**Ref:** SSD-89477725  
8 September 2026

**Proposal:** Three shop top housing buildings and one co-living building, totalling 866 dwellings including approximately 55 affordable housing dwellings to be provided in perpetuity

**Property:** 51-55 Parramatta Rd, 61 Parramatta Rd, 33 Queens Rd, 35-41 Queens Rd, and 43 Queens Rd, Five Dock

Figure 3. Building 1 upper-level plan excerpt. Appendix J1, PDF p.9, drawing 107 (GA Plan - Level 06-14), revision 28, 25 May 2026. The western dimensions are 9,300 mm and 10,670 mm. Reproduced excerpt, not to scale; use the complete architectural drawing for dimensional assessment.

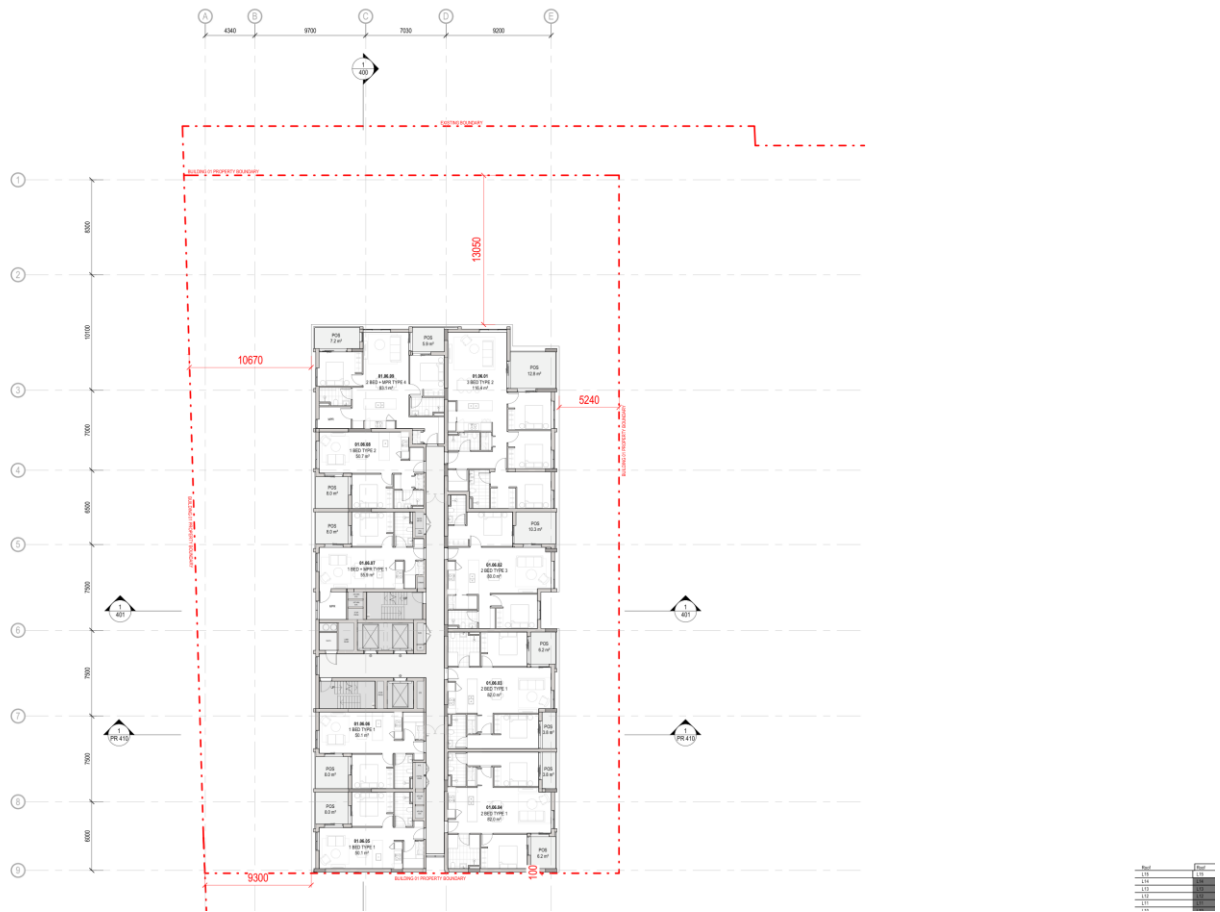
Urban Eco\_Lab identifies an Apartment Design Guide (ADG) separation issue at Building 1 and recommends revising the layout. It also identifies the retained eastern strip/deep-soil interface as a future-development risk and recommends reducing basement extent and securing the intended deep-soil zone. Building 2 does not independently achieve the cross-ventilation outcome when Buildings 2 and 3 are assessed separately; additional facade notches/vertical cuts are recommended. Urban Eco\_Lab also identifies an opportunity for a breezeway/opening at the Buildings 2/4 interface, if practicable, to improve light and passive airflow.
